Application No: EP/35/22/HH
Site Address: West House South Strand East Preston BN16 1PN
Description of works: Erection of single storey front extension, first floor front/side extension and alterations to fenestration/openings.

Thank you for your internet representation made on 17th May 2022 which has been recorded as an objection with the comments as follows:

**W ELEV**

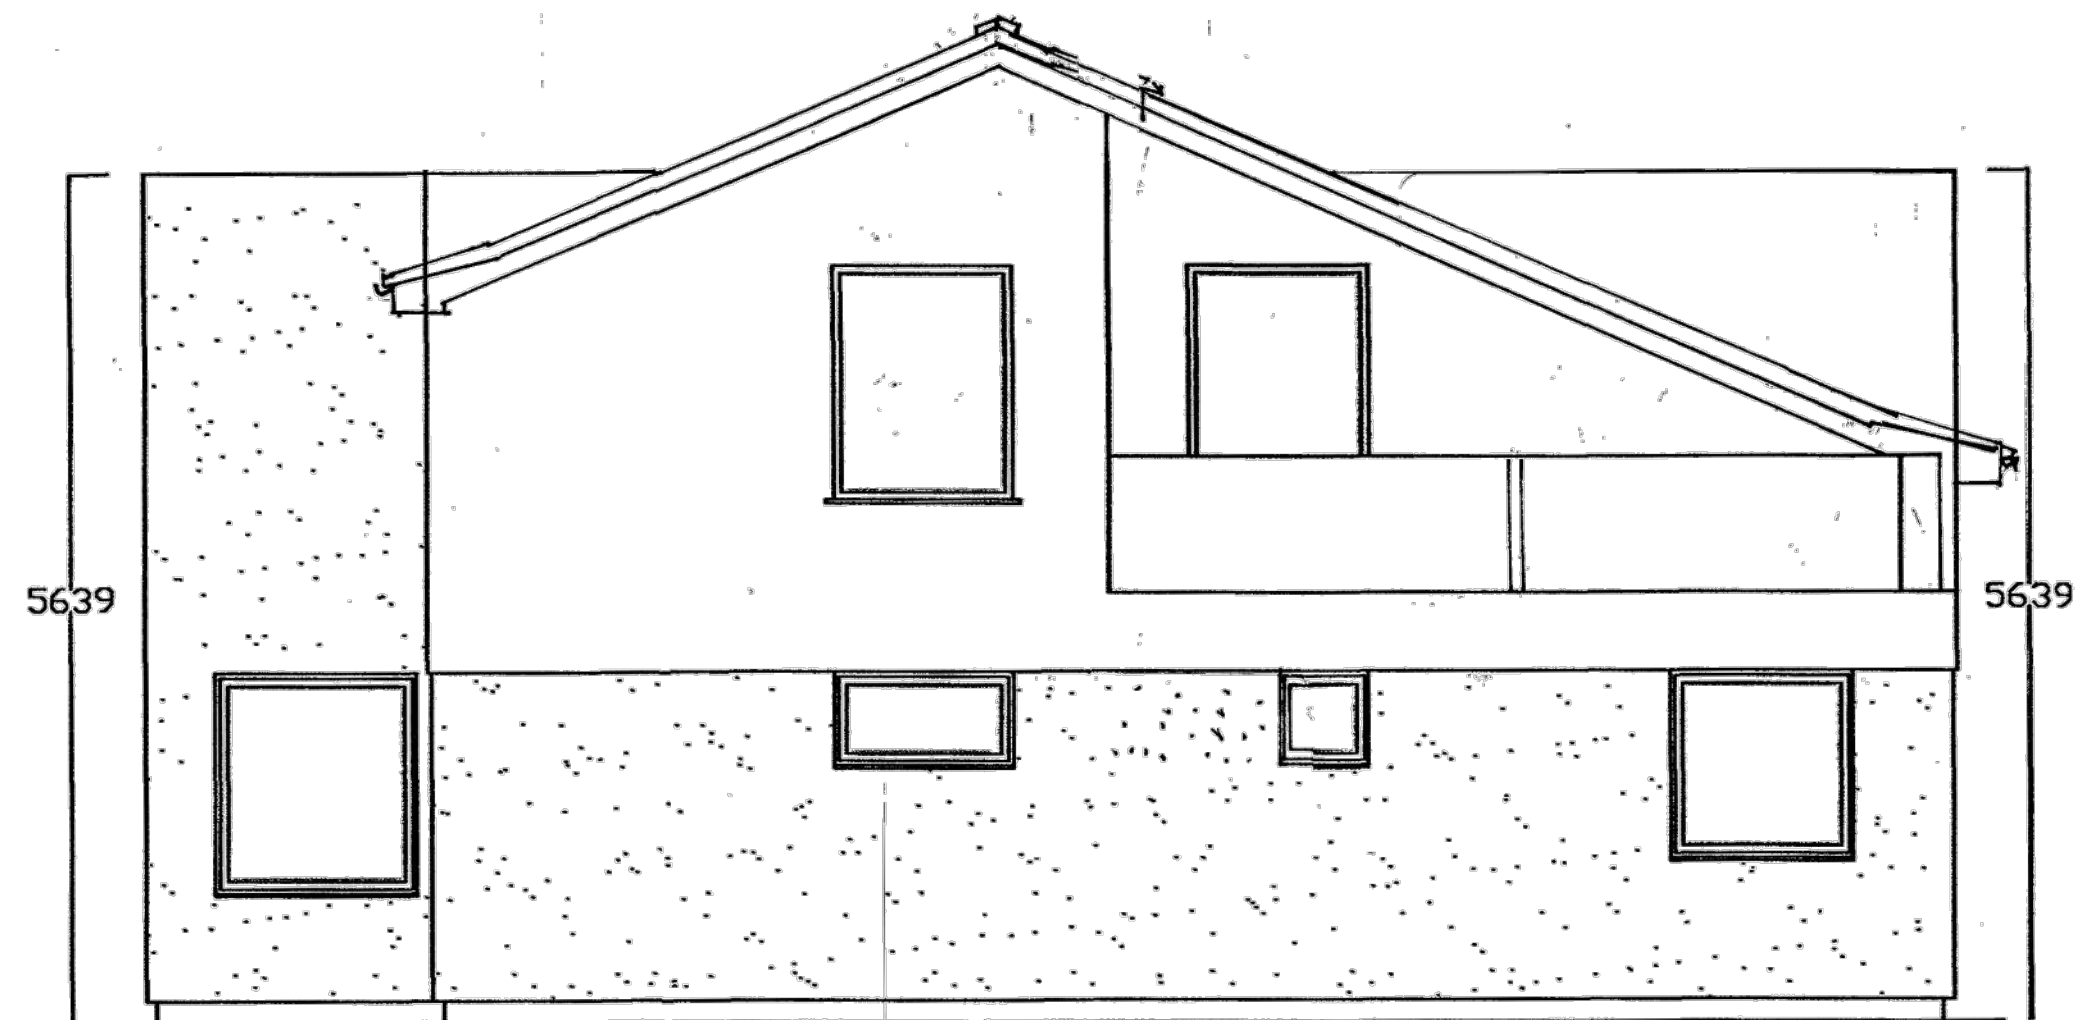
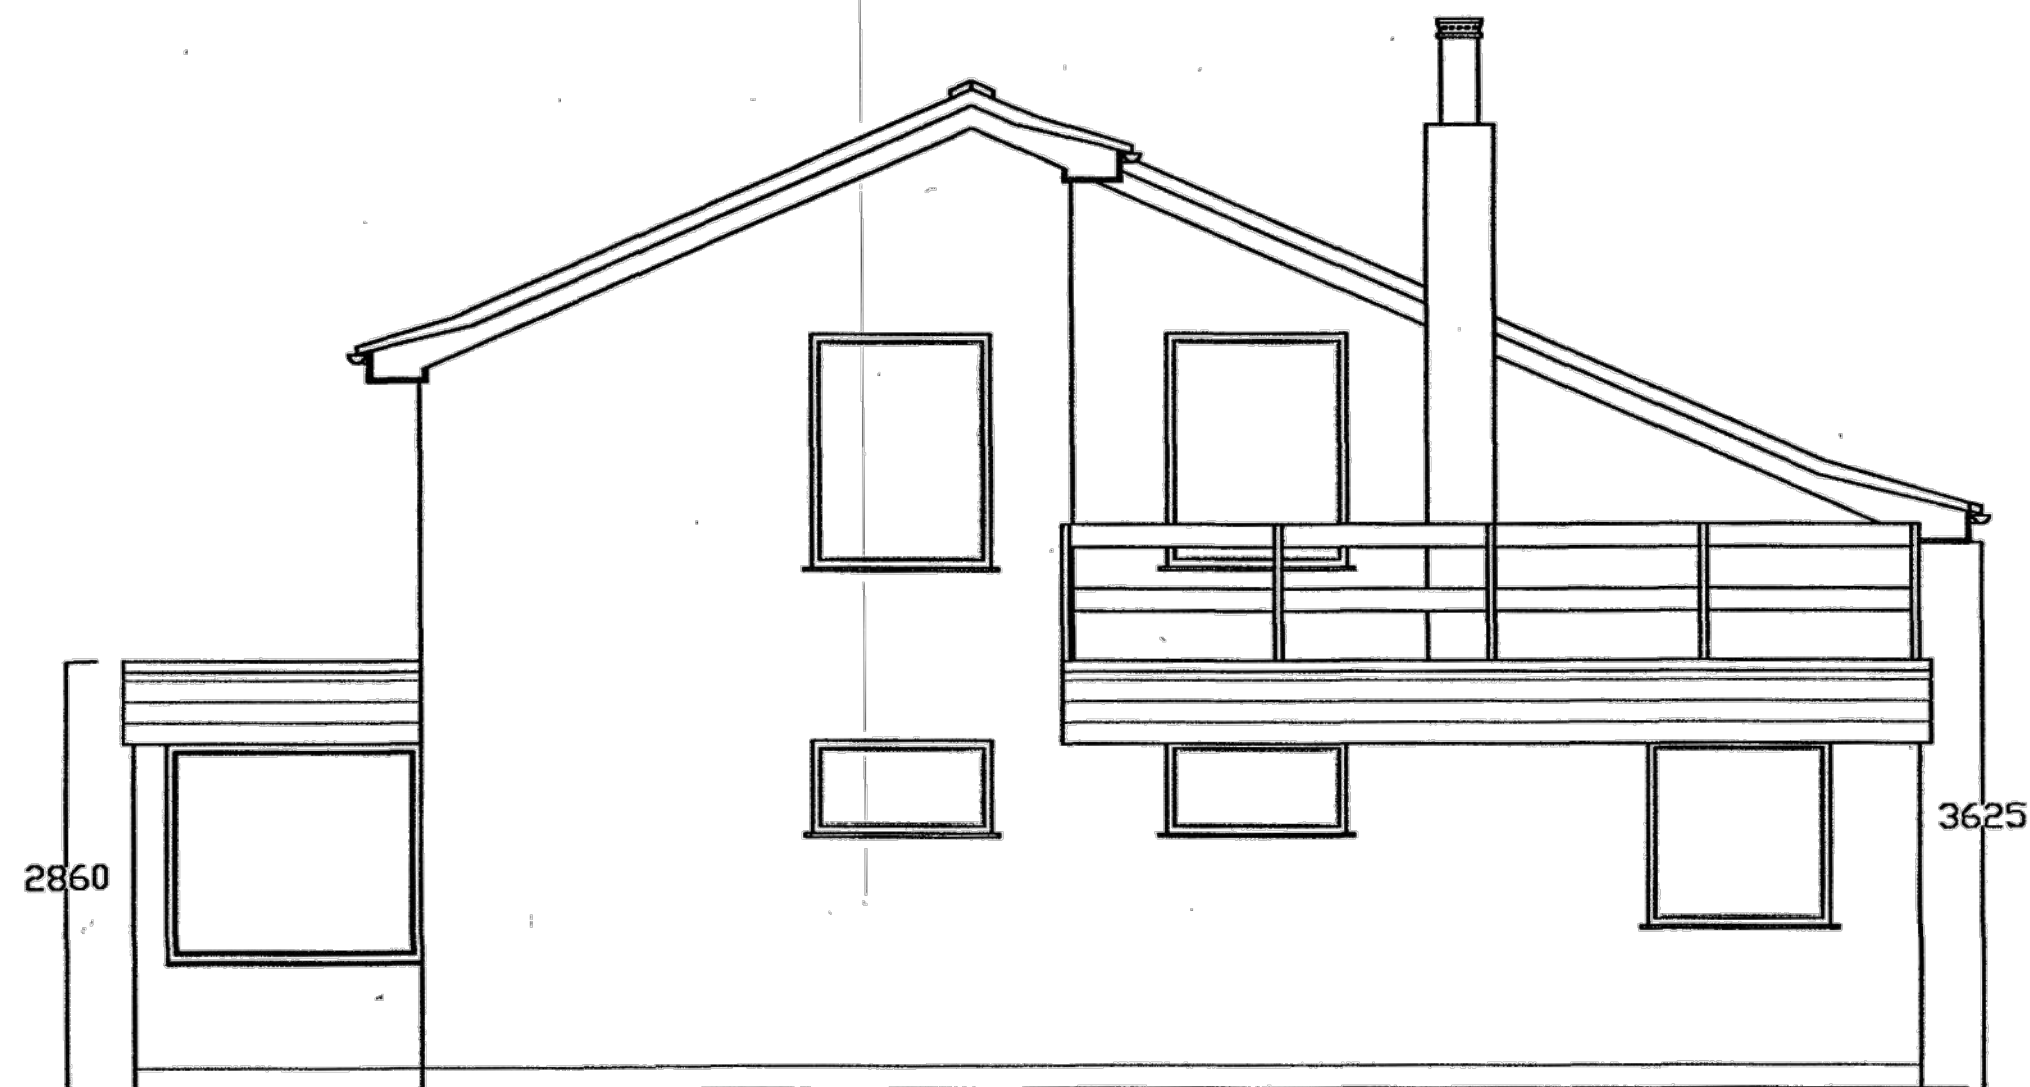
The balcony screening on the west elevation has already been implemented without permission. This originally consisted of 50 percent wooden boarding substantially screened by a mature tree and hedge. This hedge and its roots belonging to Dolphins East and the tree that straddled the boundary have been completely removed by West House and without permission from Dolphins East. As a result of these actions and the change of balcony material this balcony has become very prominent with views over Dolphins East, Dolphins West, Casa Blanca, the private garden area of Dolphins East and the driveway to all of these houses. This balcony is in constant use by the owners of West House and their two dogs which bark whenever anyone is entering or exiting the areas to these properties.
